From: Martyn White <Martyn.White@arun.gov.uk>
Sent: 20 December 2019 15:57
To: Planning.Responses <Planning.Responses@arun.gov.uk>
Subject: FP/226/19/PL

FP/226/19/PL

It is noted that this application relates to the retention of summer house/shed on land within the frontage of the Post office.

Drawing BLOCK PLAN

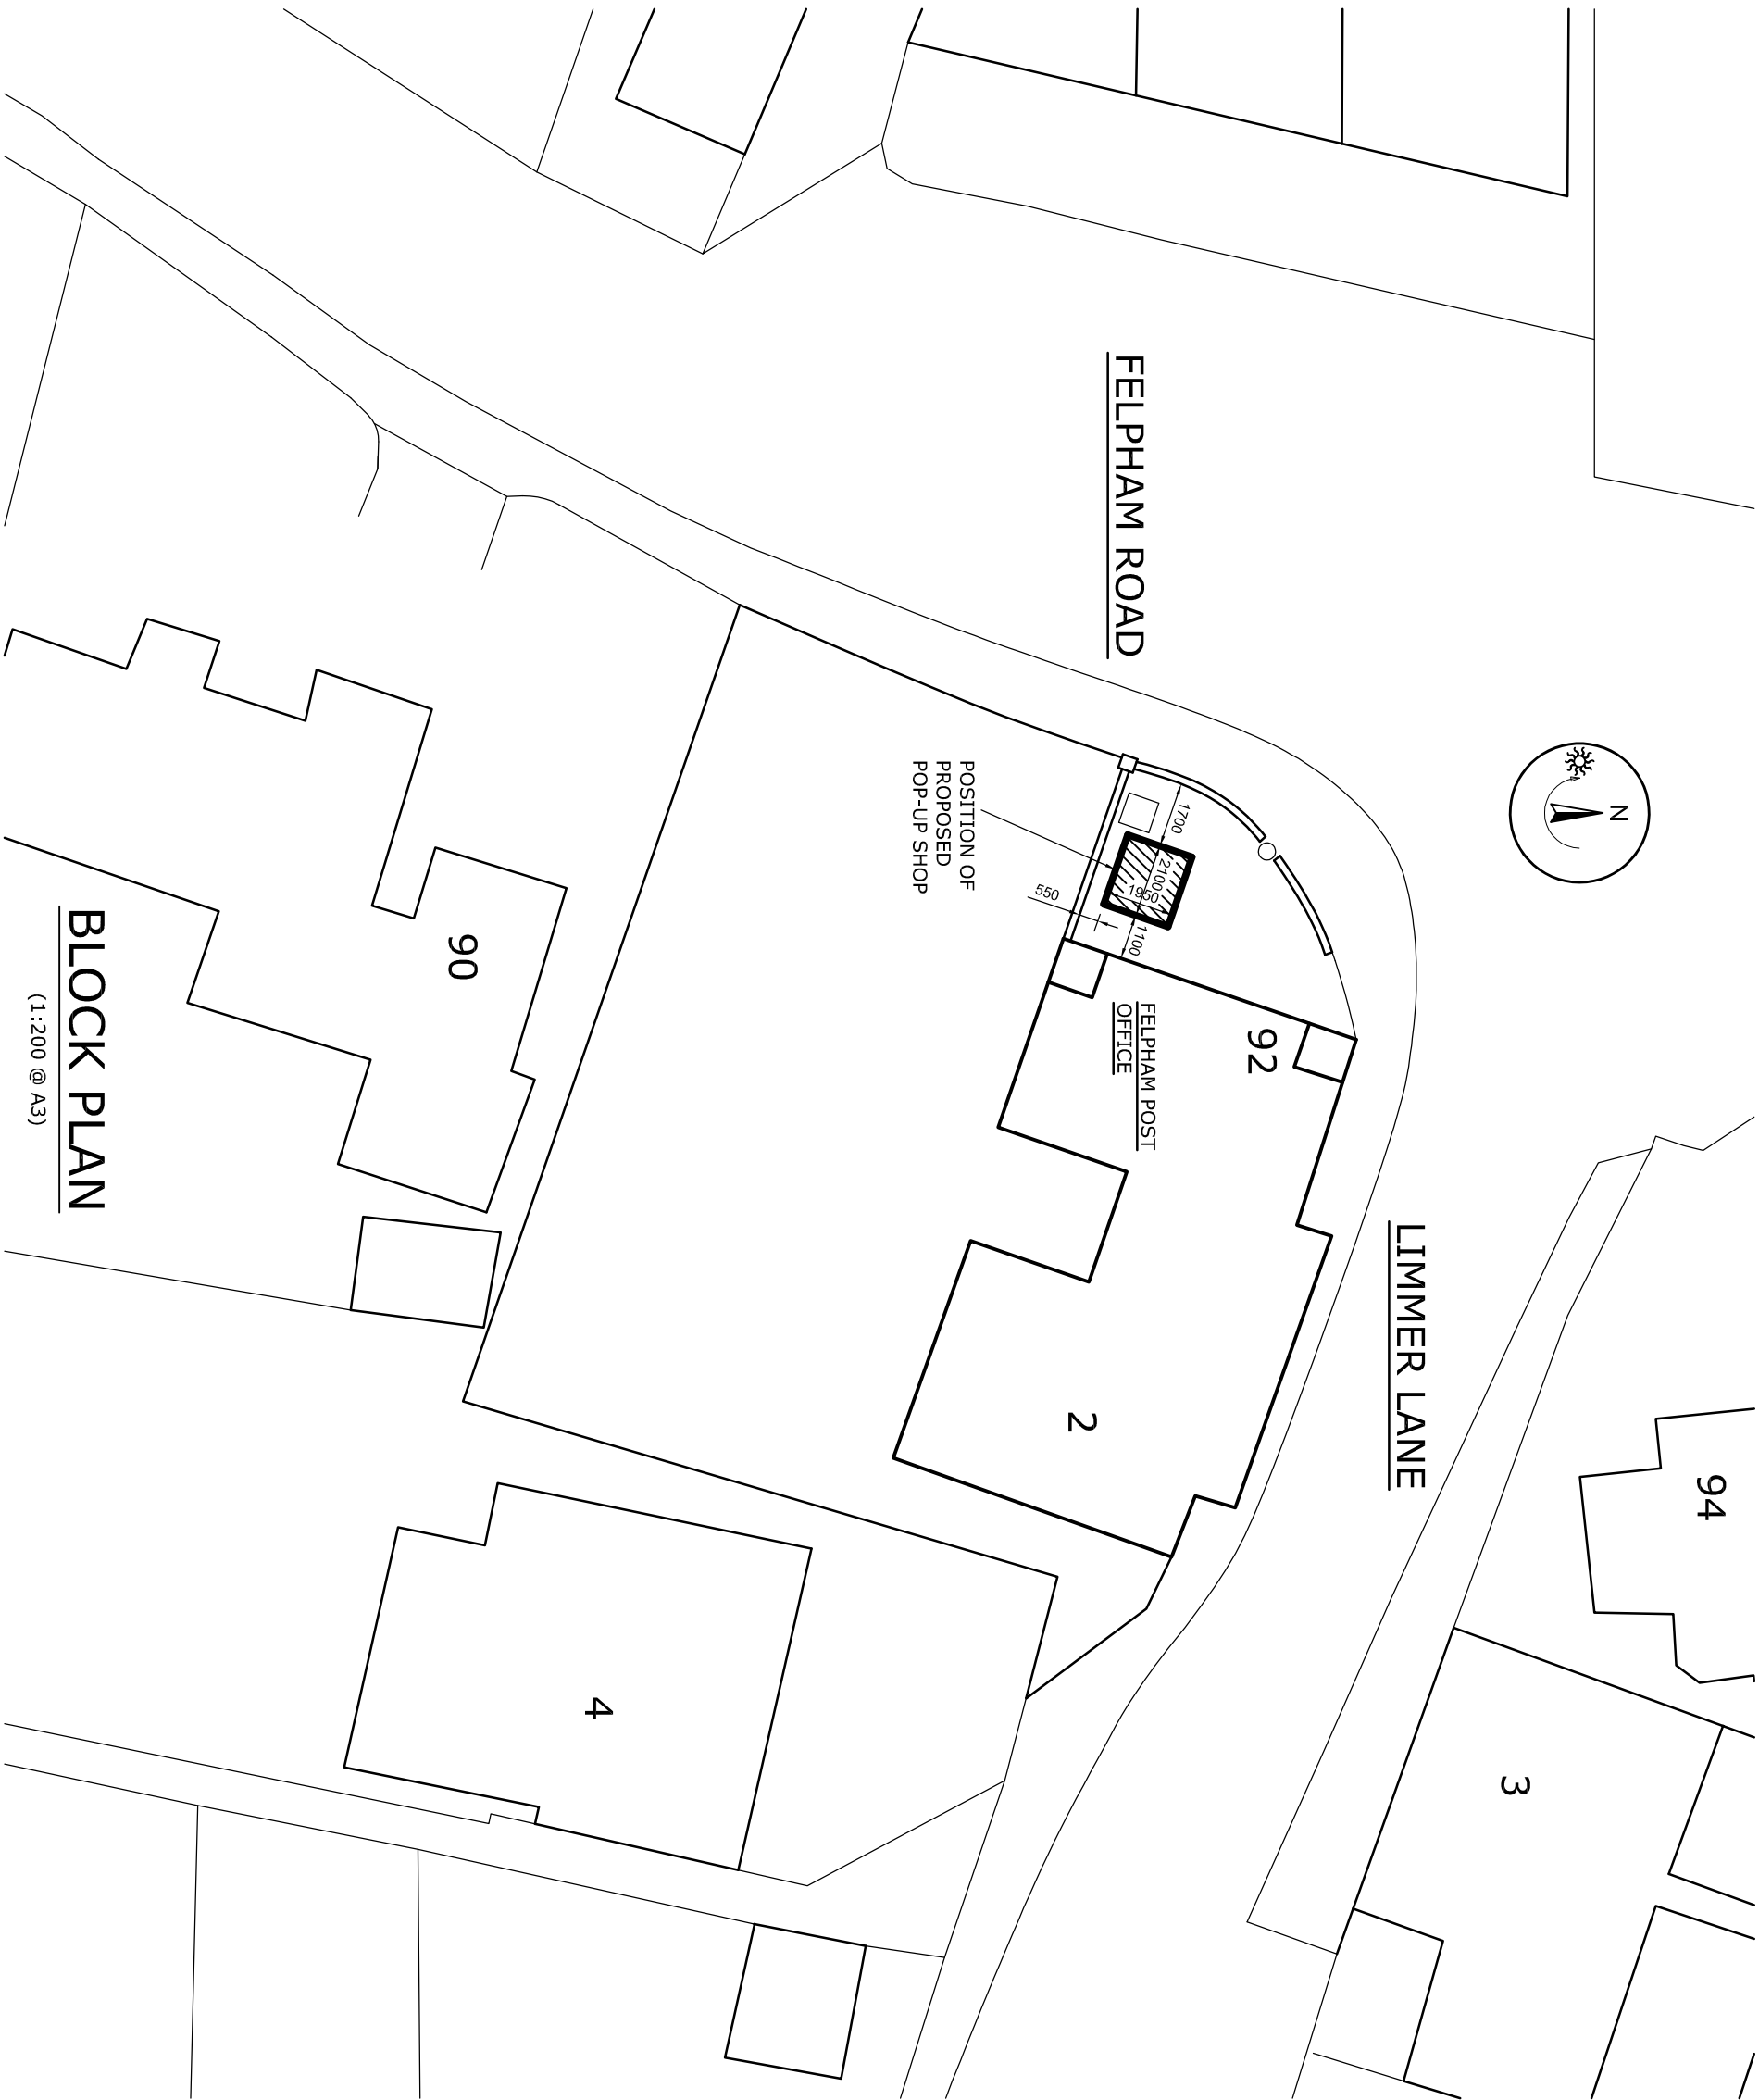
The structure in question is located within the front area of the post office building and is visible from the street. It is considered that the structure is essentially a basic summerhouse which has been repurposed for this new function. It has been painted in colours reminiscent of the nearby seaside. The use complements that of the post office and the local parade of shops, and is therefore deemed to be acceptable.

It is suggested that, if minded to approve the application that the structure be allowed to remain as long as it is in use. When this use ceases, it is suggested that the structure should be removed from its current location. Further, any replacement structure or elevational treatment (such as alternate colour scheme required as part of maintenance) should be confirmed with the LPA.
